Rezoning Transportation Analysis
Petition Number: Insert Zoning Petition #2021-213
General Location Identifier: 22706130

Revision Log:	Date	Revision Log:
	01/21/2022	First Review (WB)
	02/21/2022	Second Review (WB)
	04/19/2022	Third Review (WB)

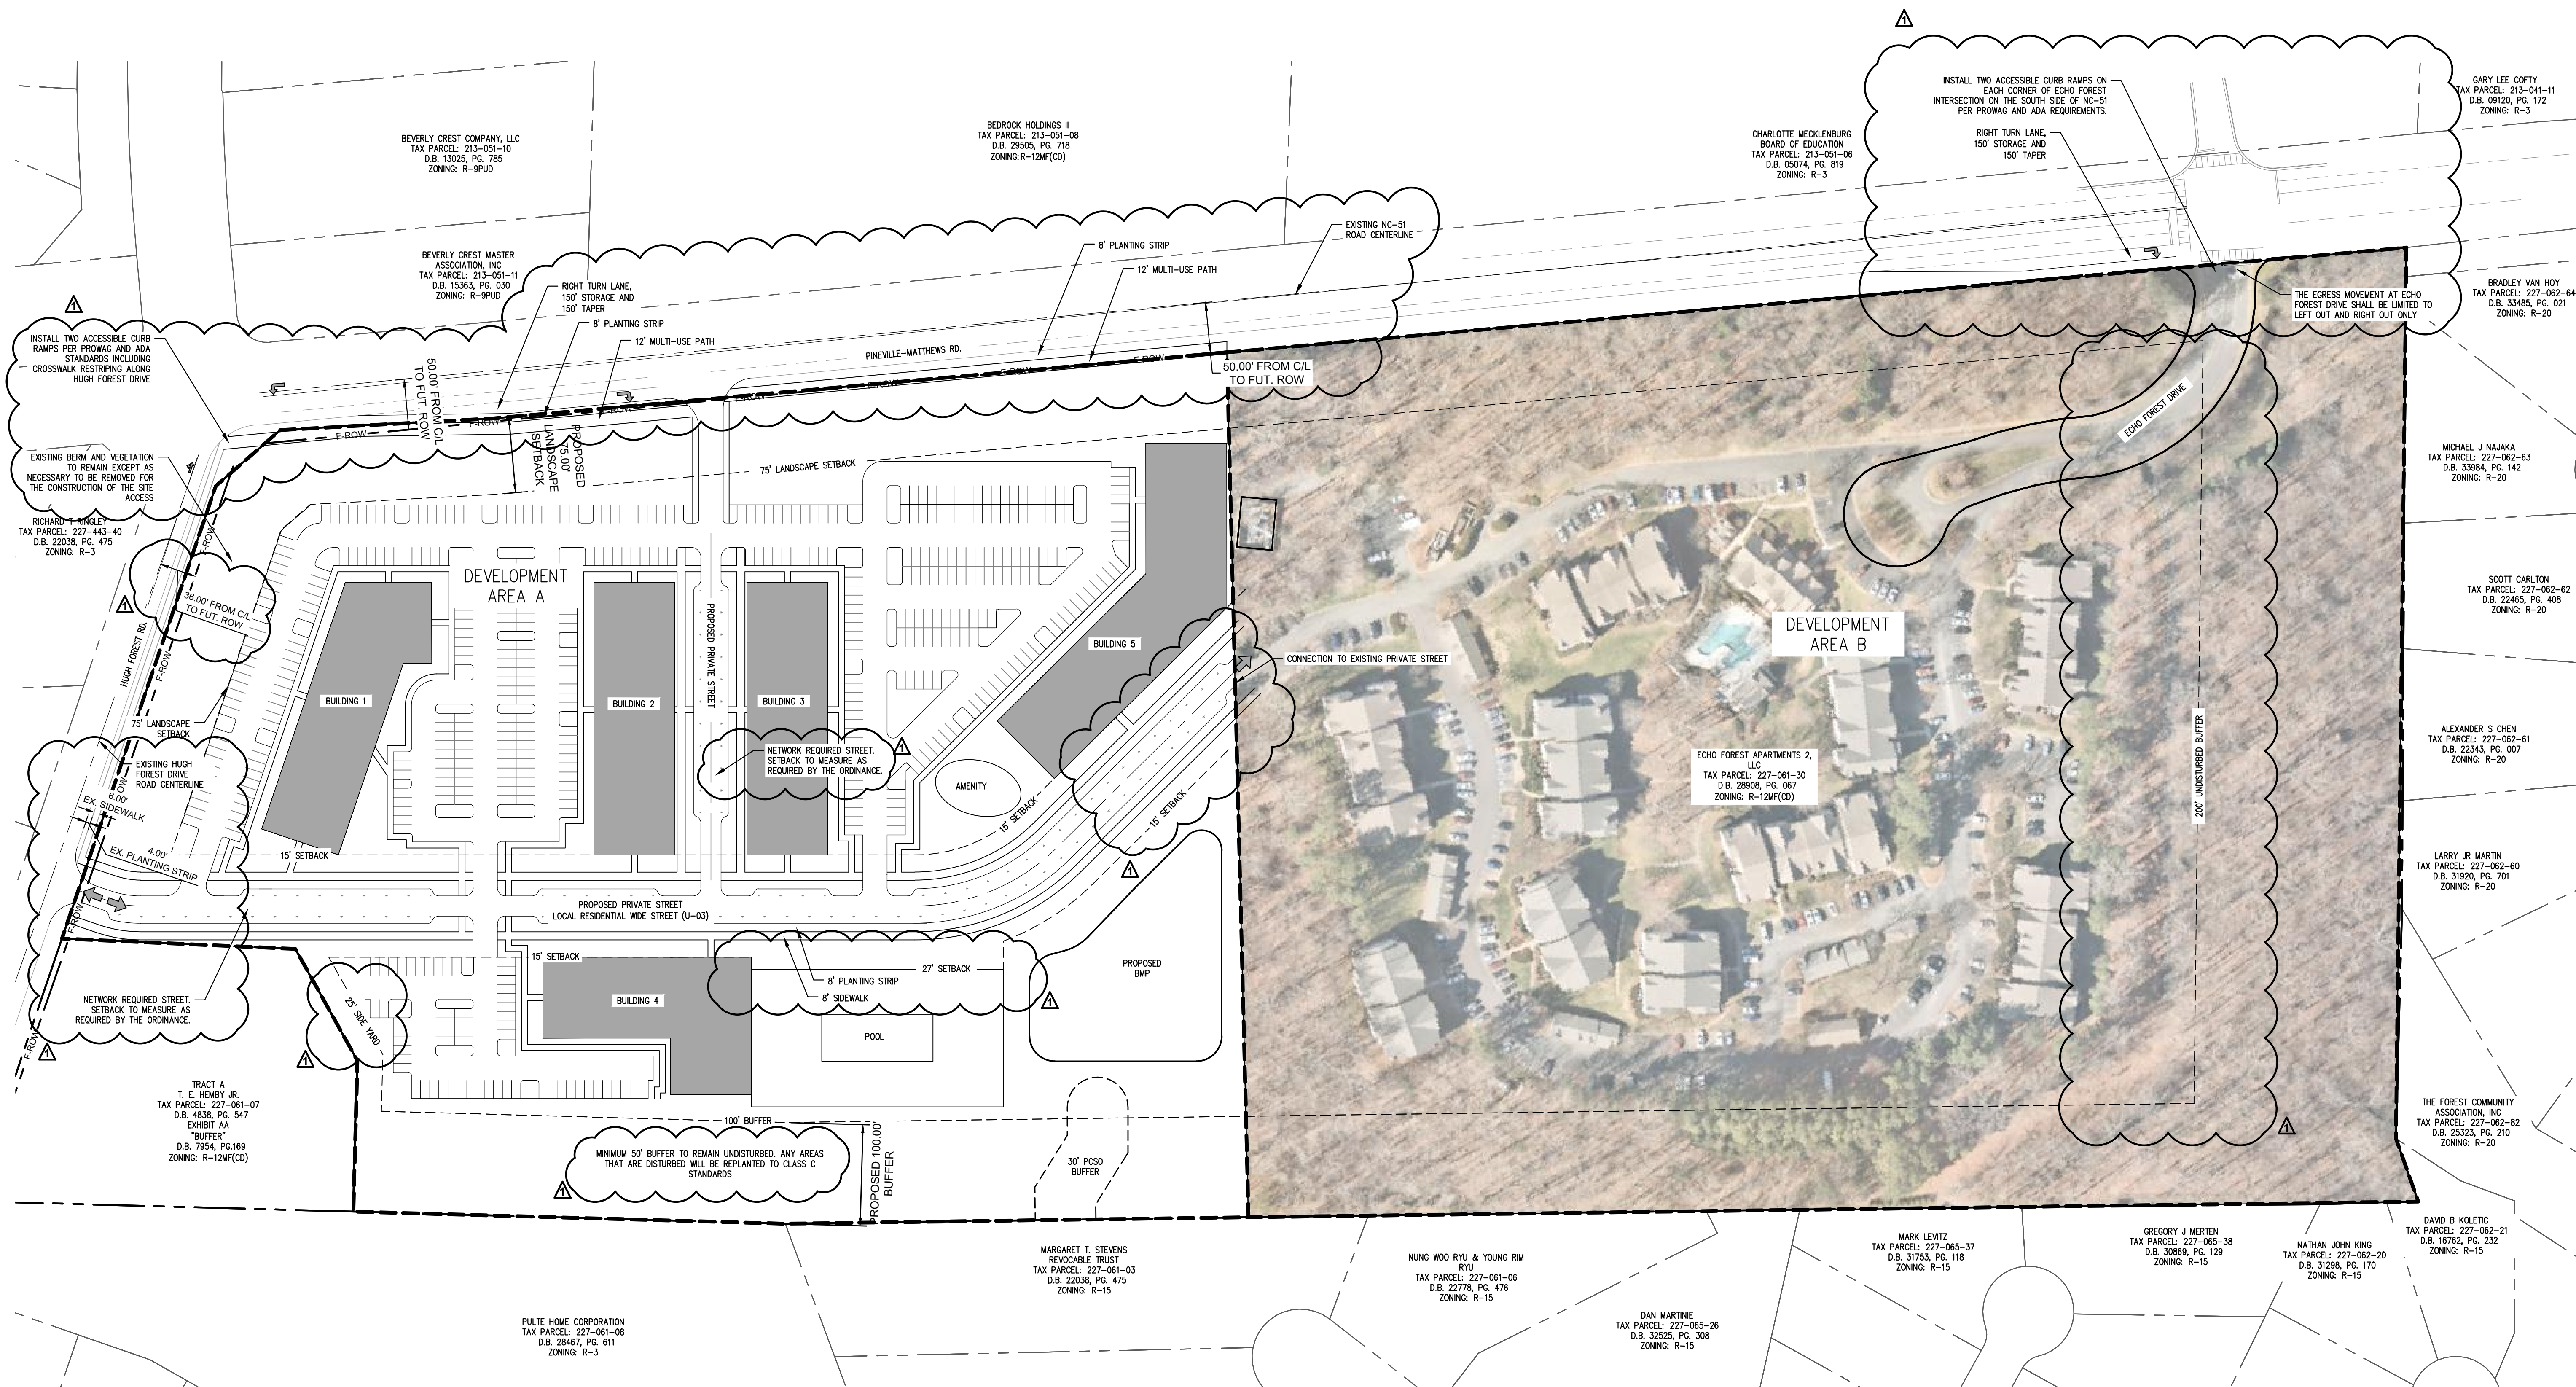
4. Site plan and conditional note revisions are needed to commit to constructing two accessible curb ramps on the southeast corner of the Hugh Forest Road intersection per PROWAG and ADA law. Commitments to include all necessary works to bring the pedestrian crossing into ADA and PROWAG compliance, including crosswalk restriping.

5. **Comment Clarification (Site plan reviewed on 2/21/22):** Site plan and conditional notes revisions are needed to commit to construct bicycle facilities by installing a 12-foot multi-use path along the site's entire Pineville-Matthews Road frontage in accordance with the Charlotte BIKES Policy. The site's frontage includes both Area's A and B.

- 11. **New Comment** (added on 2/21/22 to address sight distance concerns): Petitioner to provide Intersection Sight Distance (ISD) at proposed driveway access points. ISD must be shown in both horizontal and vertical dimensions (plan/profile) along the sight line, not the roadway centerline. The horizontal dimensions (plan) shall include contours corresponding with the vertical dimensions (profile).

- 12. **New Comment** (added on 2/21/22 to address traffic concerns): Petitioner to provide passenger car and truck turning movements for U-turns movements made on Pineville-Matthews Road at the Hugh Forest Road intersection.
